From: alan.story@hertfordshire.gov.uk
To: [Planning](#)
Subject: Planning application 6/2019/0882/OUTLINE - Colesdale Farm
Date: 30 May 2019 09:32:37

District ref: 6/2019/0882/OUTLINE

Colesdale Farm
Northaw Road West
Northaw
Potters Bar
EN6 4QZ

Outline permission for residential development of site of up to 38 dwellings following demolition of the existing buildings and structures with all matters reserved apart from access

DRAWING NUMBER: 24794_08_020_01

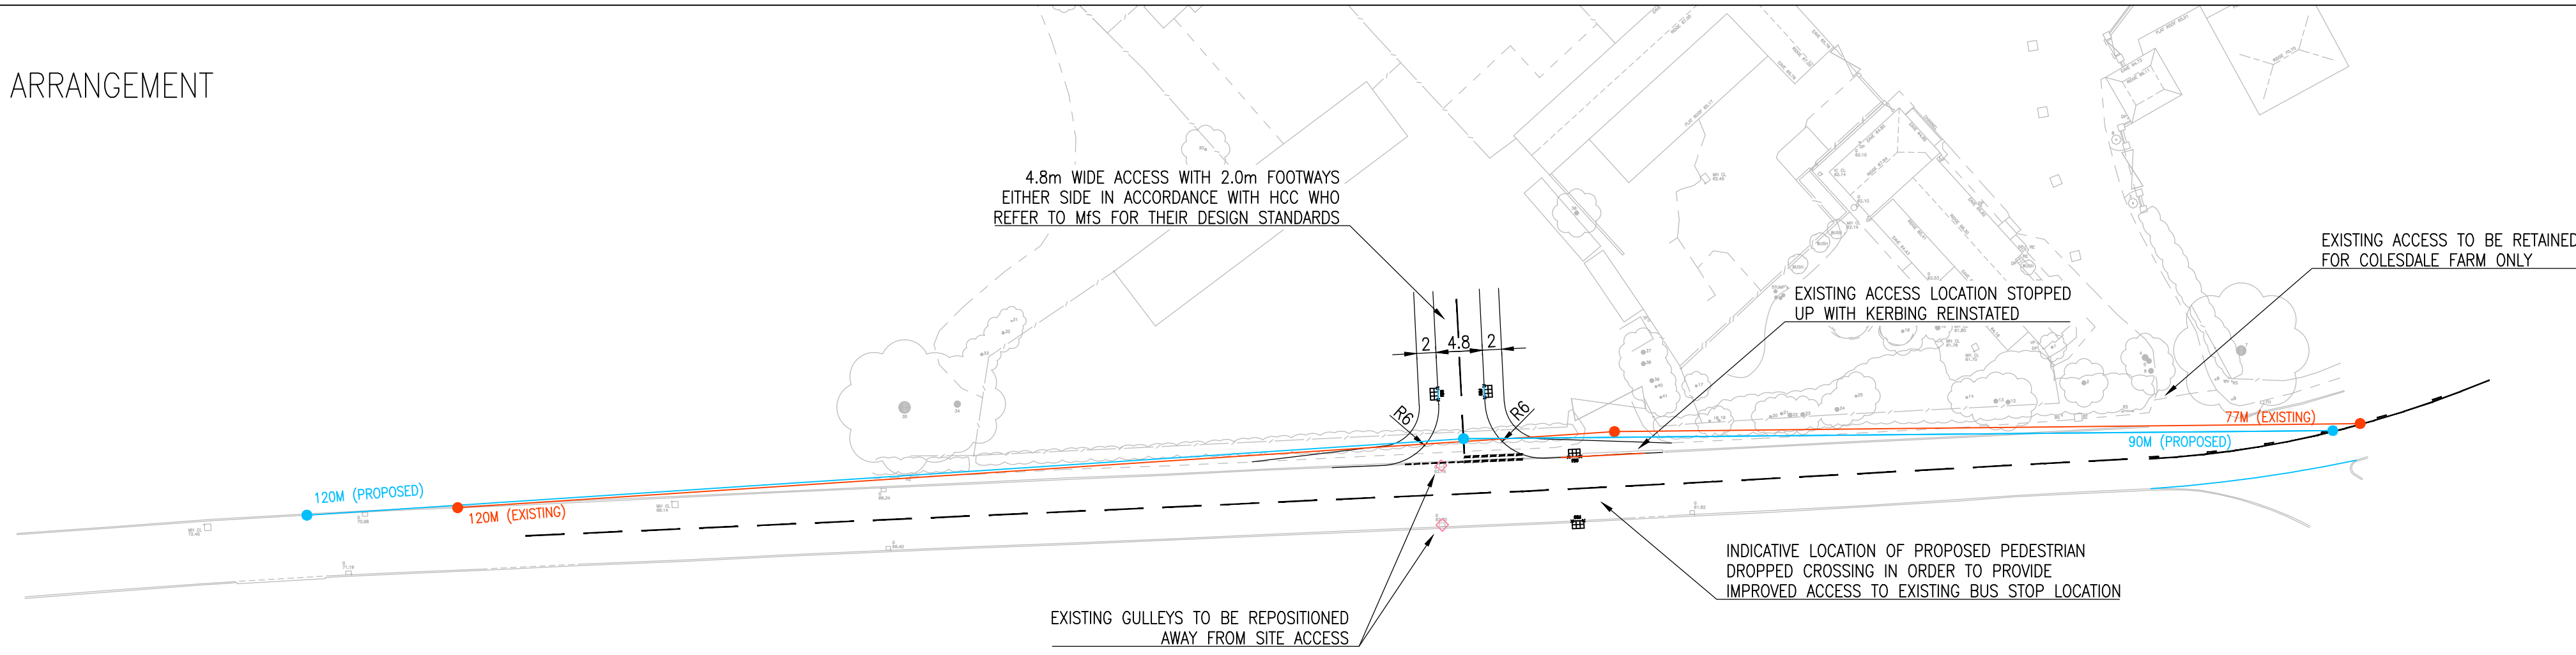
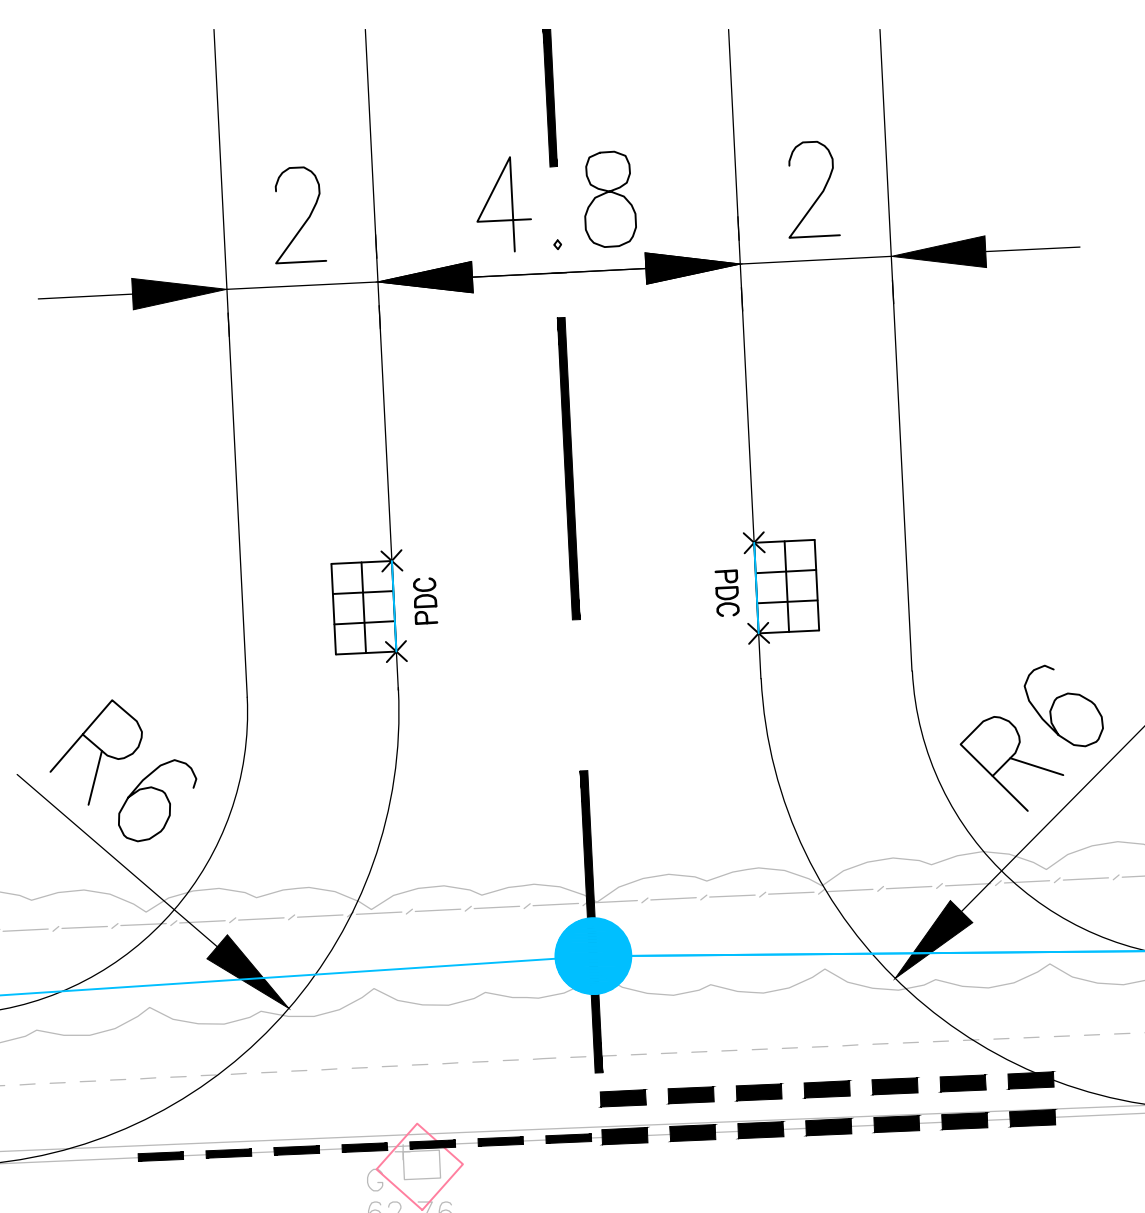
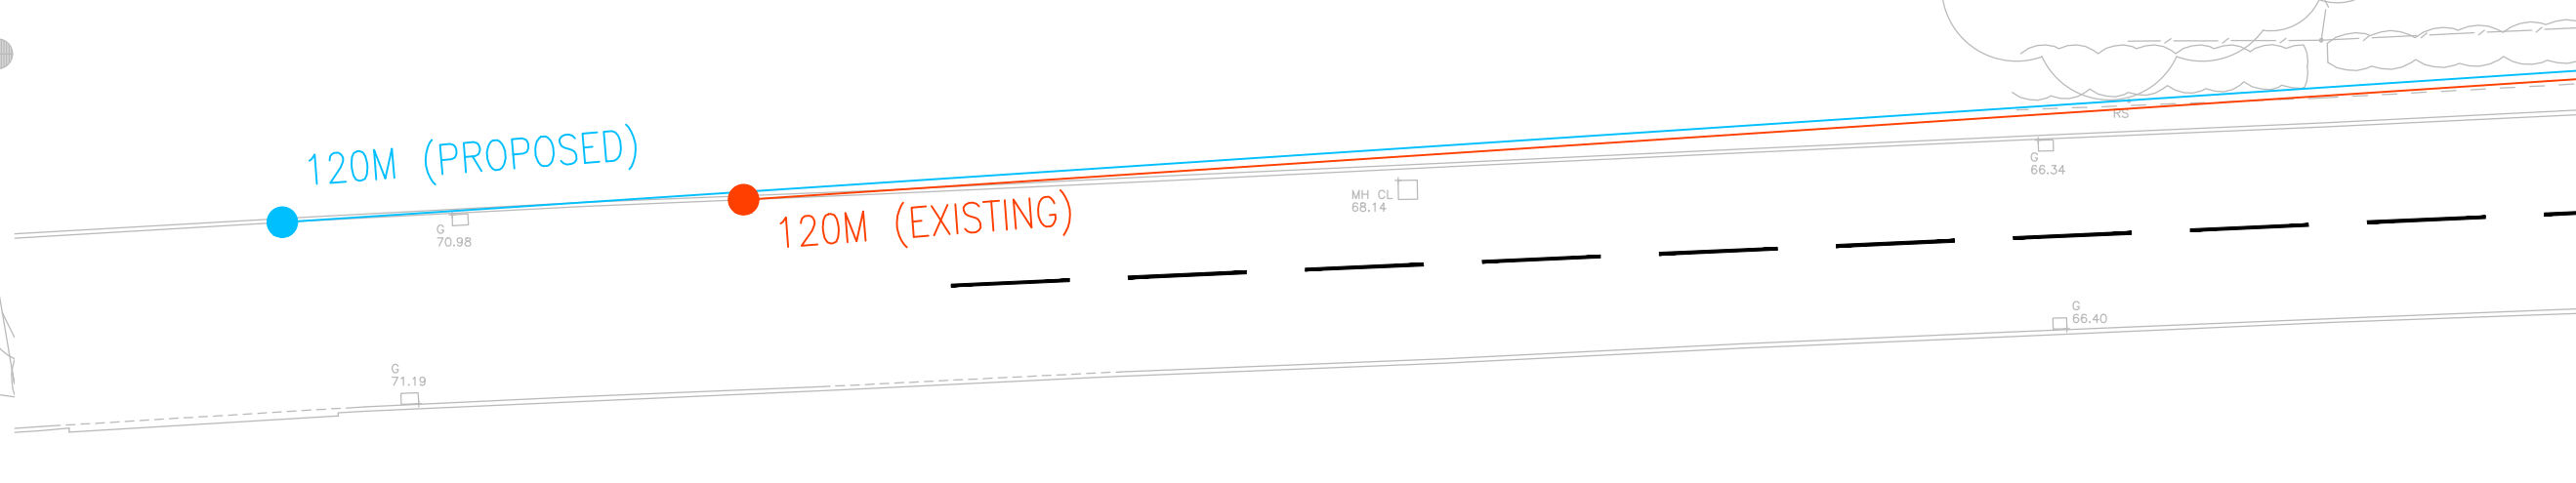
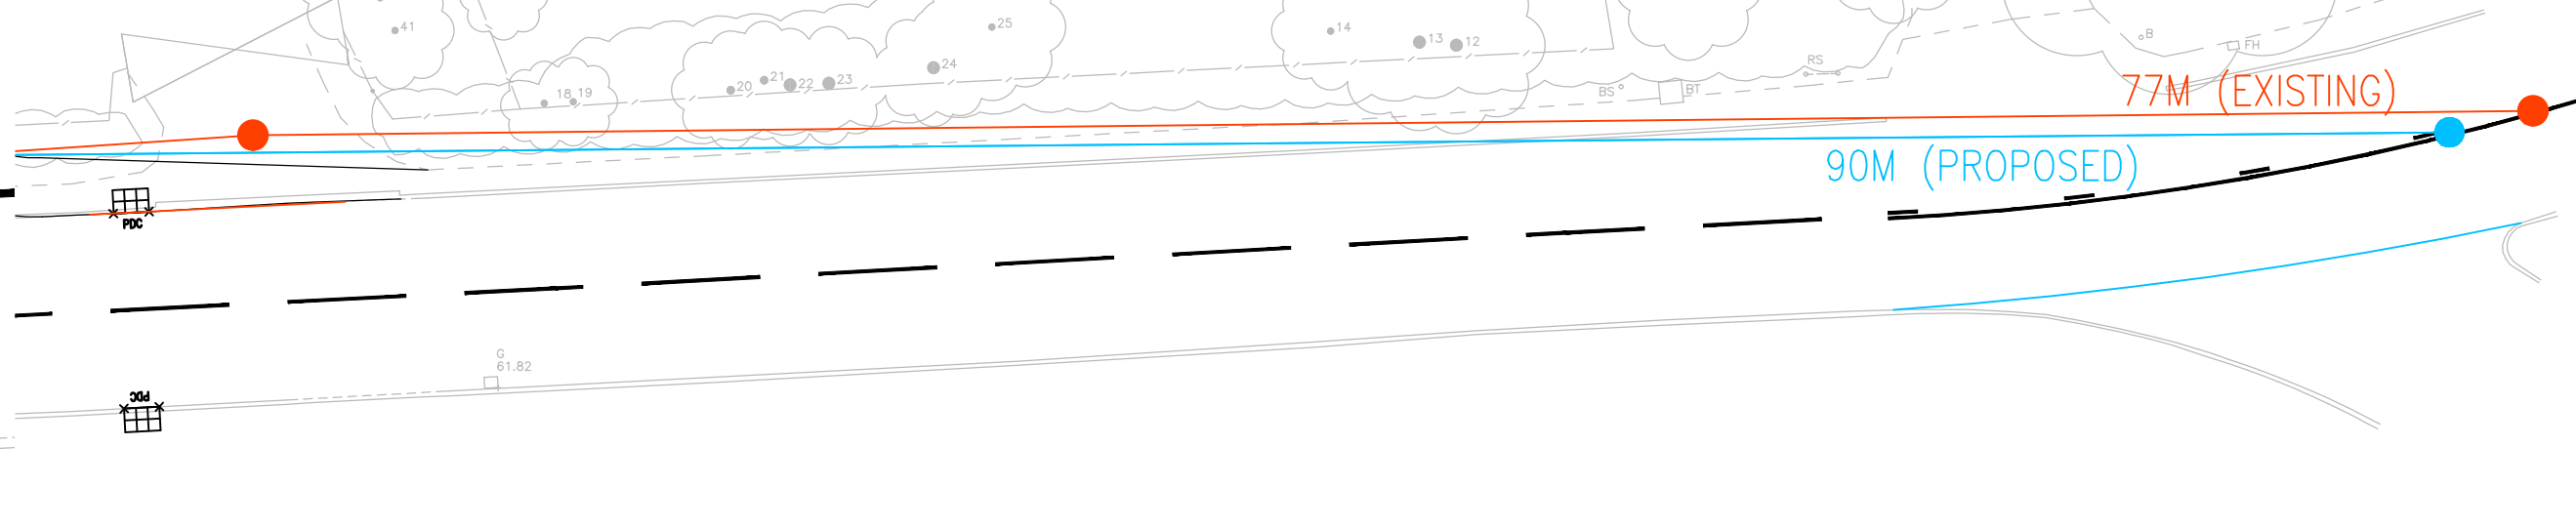
Visibility from the proposed improved access is shown on drawing 24794_08_020_01 (appendix F to the TS) and shown as 2.4m x 45m to the west and 2.4m x 63m to the east. Reference is made in this drawing that such splays are appropriate for the assessed 85th %'ile for Northaw Road West, with this drawing annotated to suggest that the TS details such speed assessment.

Whilst the TS provides evidence that 85th %'ile is beneath 37.5mph, it shall be difficult to argue that the characteristics of Northaw Road West at this location are anything other than serving a "movement" function. Whilst the existence of the access cannot be ignored, it is substandard in terms of visibility. The proposals create a new access (albeit at loss of existing), however, such access should be provided in a safe manner.

Vehicle speeds on NRW presented within the TS have regard to ATC data from the County Councils own apparatus (site 478401), this site is located approx 330m east of the junction of Cattlegate Road with NRW / NRE. As such this count site is in a position that does not compare with the application site. Vehicles at count site are either aware of the approach of the Cuffley urban area or have recently left it, with vehicle speeds within the urban area subject to 30mph limit and subject to speed management arrangements. The topography of NRW outside the site has a notable gradient, no active frontages and therefore the Highway Authority consider that vehicle speeds at the proposed access are significantly greater than presented within the TS.

The above situation directs that there is insufficient evidence that the use of MfS standards is appropriate. The proposals fail to provide visibility from the proposed access to DMRB levels. Whilst levels of intensification of use (above) are low, there is sufficient intensification that the access shall require improvement to provide a safe connection with the Secondary Distributor. Such a view is supported by the fact that there is a cluster of accidents at the junction of NRW / NRE / Cattlegate Road. Whilst many accidents suggest that causative factors were not speed related, there are sufficient accidents involving inappropriate speeds to support the view that the use of the selected ATC count site is inappropriate for use within this matter.
